City of Albuquerque

Re: **Fire Station No. 14 Grading and Drainage Plan**
Engineer's Stamp dated 6-22-98 (L9/D21)
Engineering Certification dated 9-3-99

RE: FIRE STATION NO. 14, 98th ST. & EUCARIZ(L9-D21). REVISED GRADING AND DRAINAGE PLAN FOR SITE DEVELOPMENT PLAN FOR BUILDING PERMIT, BUILDING PERMIT, AND FOUNDATION PERMIT. ENGINEER'S STAMP DATED MAY 21, 1998.

Fire Station No. 14 Grading and Drainage Plan

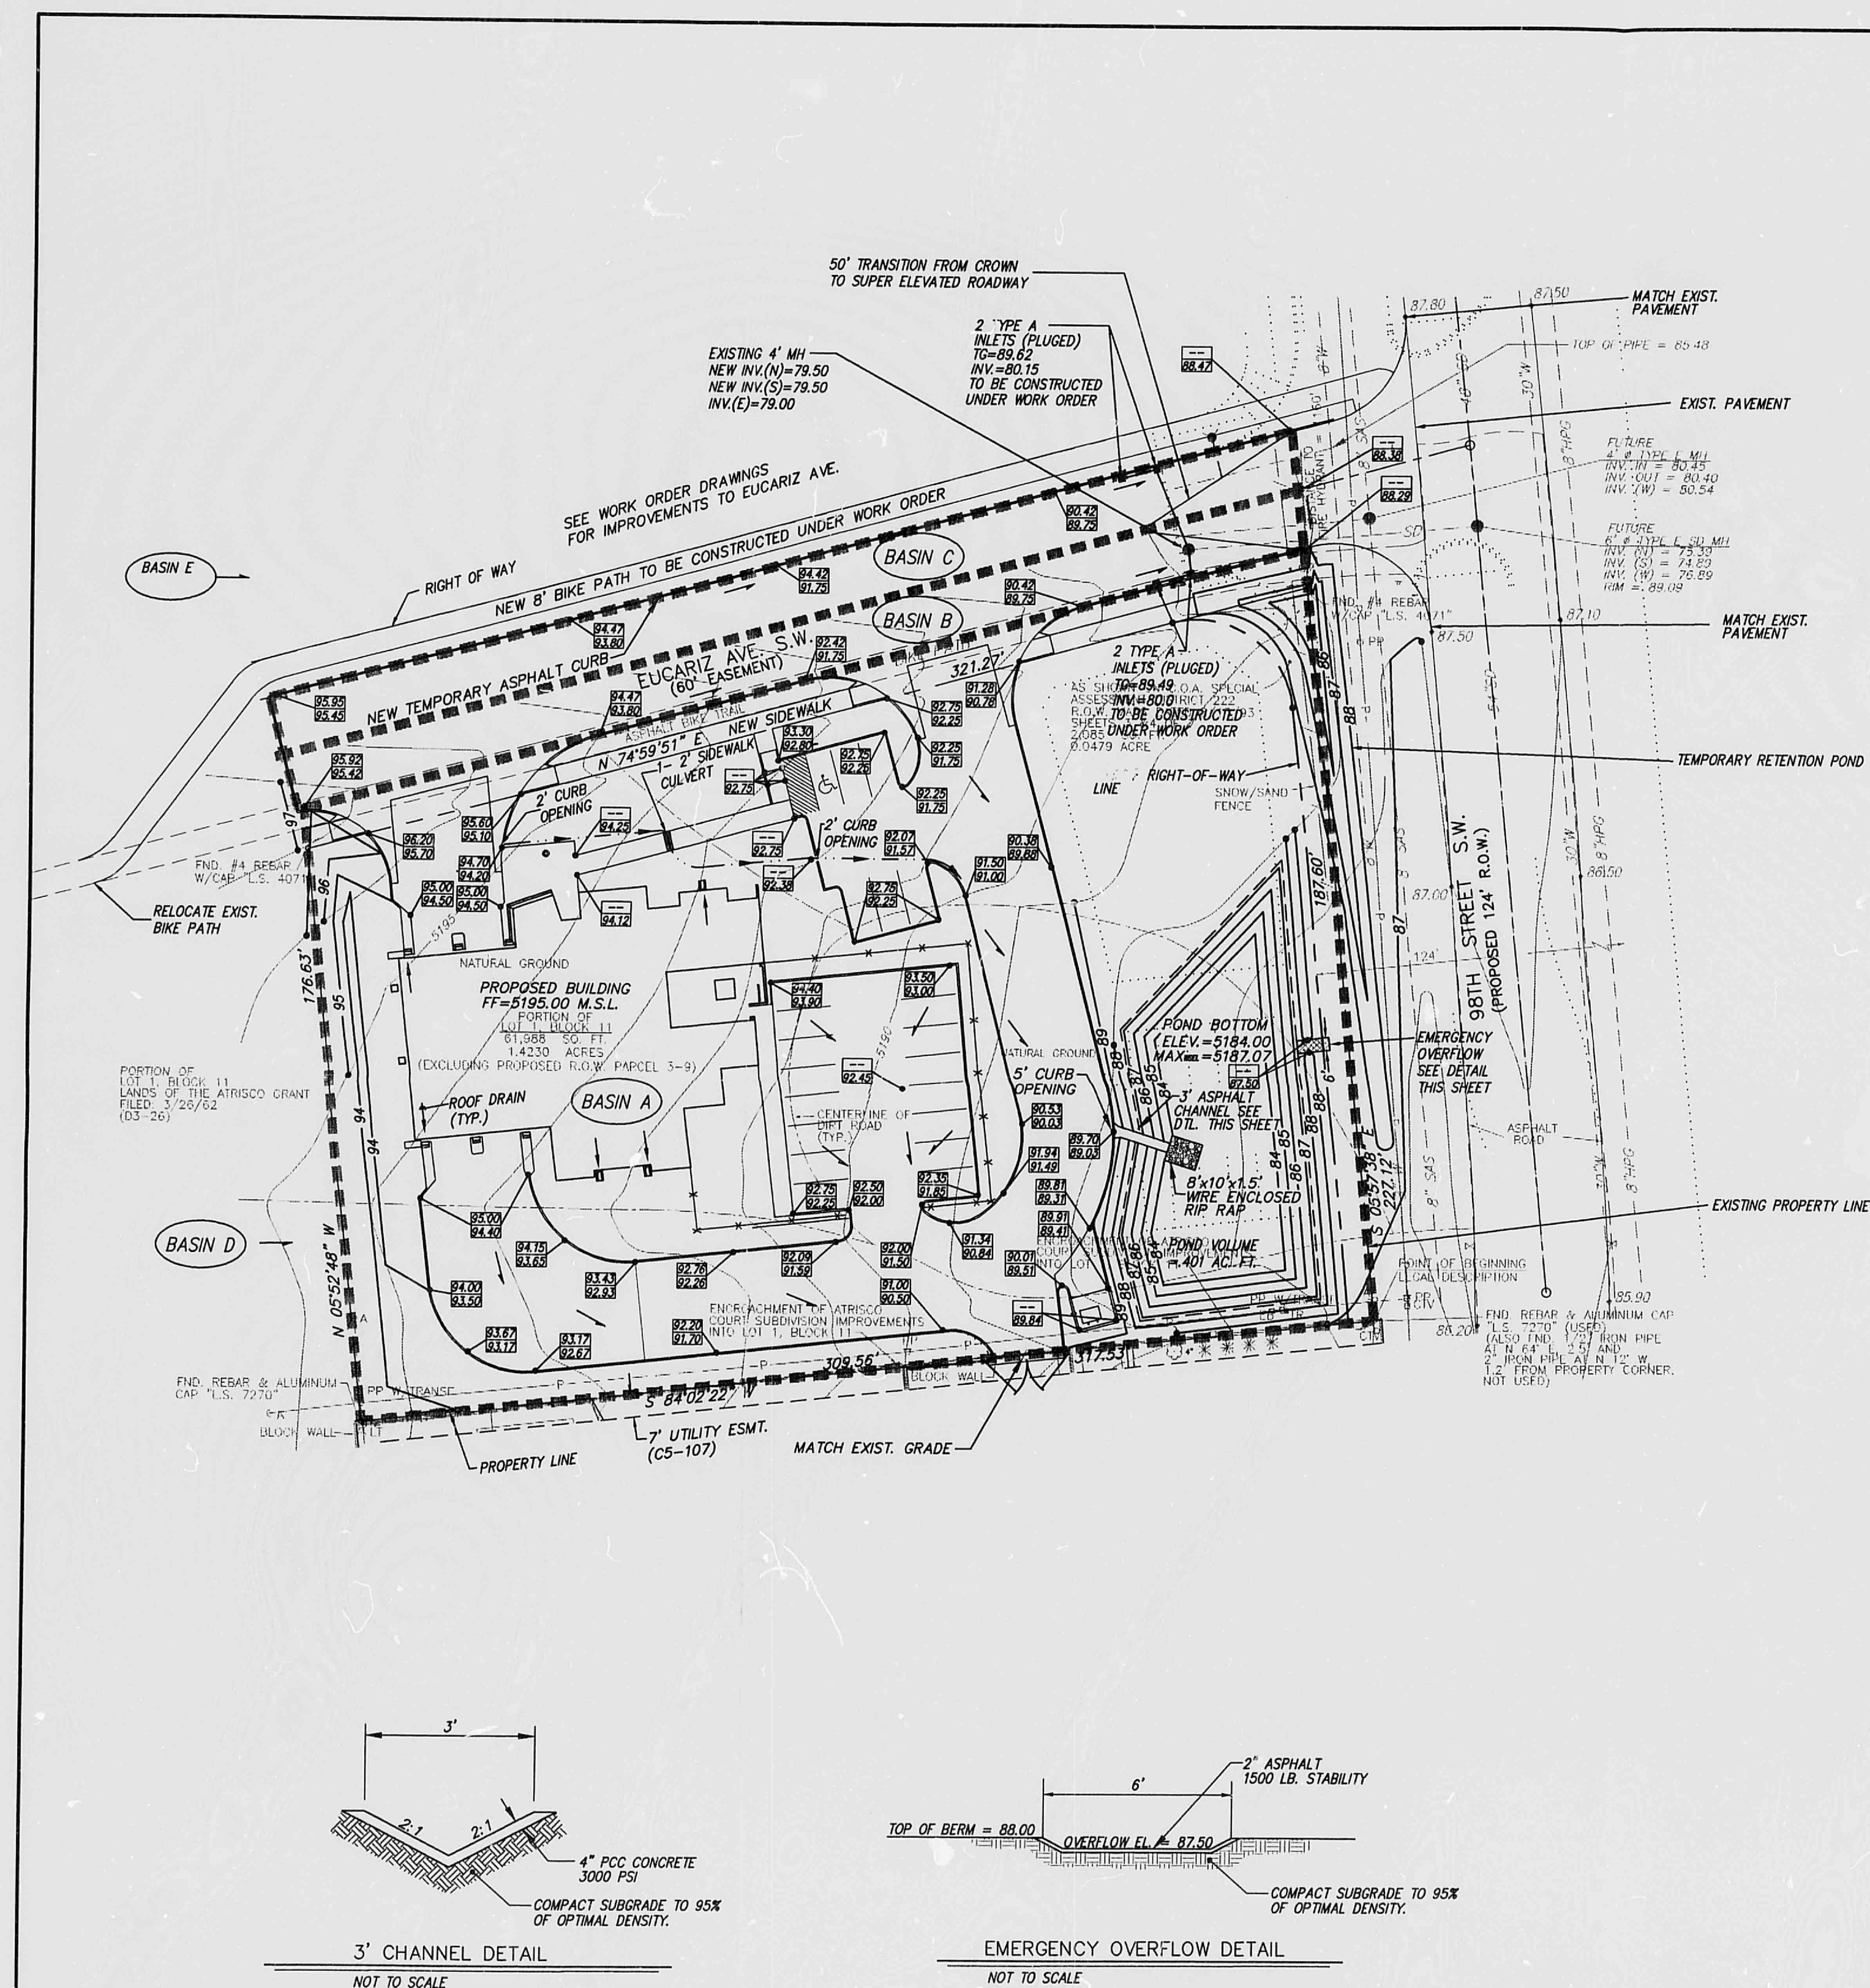
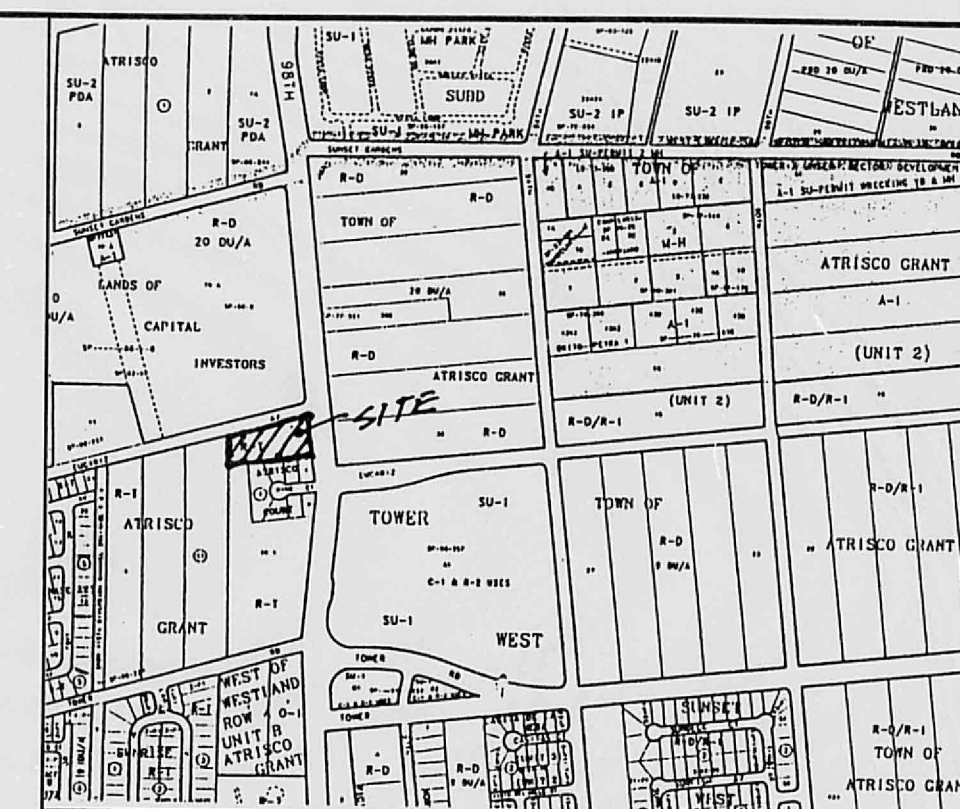
1. This submittal, as the one stamped May 5, 1998, needs to furnish sufficient information, e.g., basin limits, to show the disposition of storm drainage from Basins B, C, D and E, including Eucariz Avenue west of the Fire Station for interim and developed conditions.
2. Include street design - cross-sections and grades - for 98th St. and Eucariz Ave. in plan. Spot elevations as per Eucariz are fine.
3. Retention ponds must be designed for 100-year 10-day storm volume. When S&D 222 is done, will the main pond discharge to the 54-inch storm sewer at the manhole shown in 98th St. at the south end of site? Does the temporary pond at the corner of Eucariz and 98th receive flow from other than Basin B? What will be its final status?

1. This submittal, as the one stamped May 5, 1998, needs to furnish sufficient information to show the disposition of storm drainage from Basins B, C, D and E, including Eucariz Avenue west of the Fire Station.
show in an developed condition + include
2. Cross-sections of streets, 98th in particular, would be helpful.
street design for 98th EUCARIZ - include in plan.
3. When SAD 222 is done, will the main pond discharge to the 54-inch storm sewer at the manhole shown in 98th St. at the south end of site? Does the temporary pond at the corner of Eucariz and 98th receive flow from other than Basin B? What will be its final status?
show on-site storm drains

Retention ponds must be shown for 100 yr ten-day storm volume.

1. The requested information has been enclosed. The basin boundaries have been reanalyzed resulting in a smaller discharge for off-site basin E. The undeveloped flow from basin E currently discharges to the northwest portion of Eucariz and 98th Street. This has remained unaltered. The existing developed flow from off-site basin D will enter the site and be retained on-site.

2. Spot elevations have been added to 98th Street. The improvements to Eucariz are included in the Work Order drawing being prepared by our firm. I have attached the graph used to design Eucariz with a slope of 2.16%. The spot elevations along 98th Street are the existing elevations. I have attached the future elevations per the preliminary SAD 222 drawings.

3. The volume of the on-site pond has been increased to accommodate the 100 year-10 day storm. When SAD 222 is constructed the on-site pond will discharge to the back of the inlet located on Eucariz. The temporary pond located at the southwest corner of Eucariz and 98th Street has been sized to accommodate the flow generated from the paving of Eucariz only. Once SAD 222 improvements are completed the flow within Eucariz will be captured by the constructed inlets which will be plugged for the interim, therefore the pond will go away.
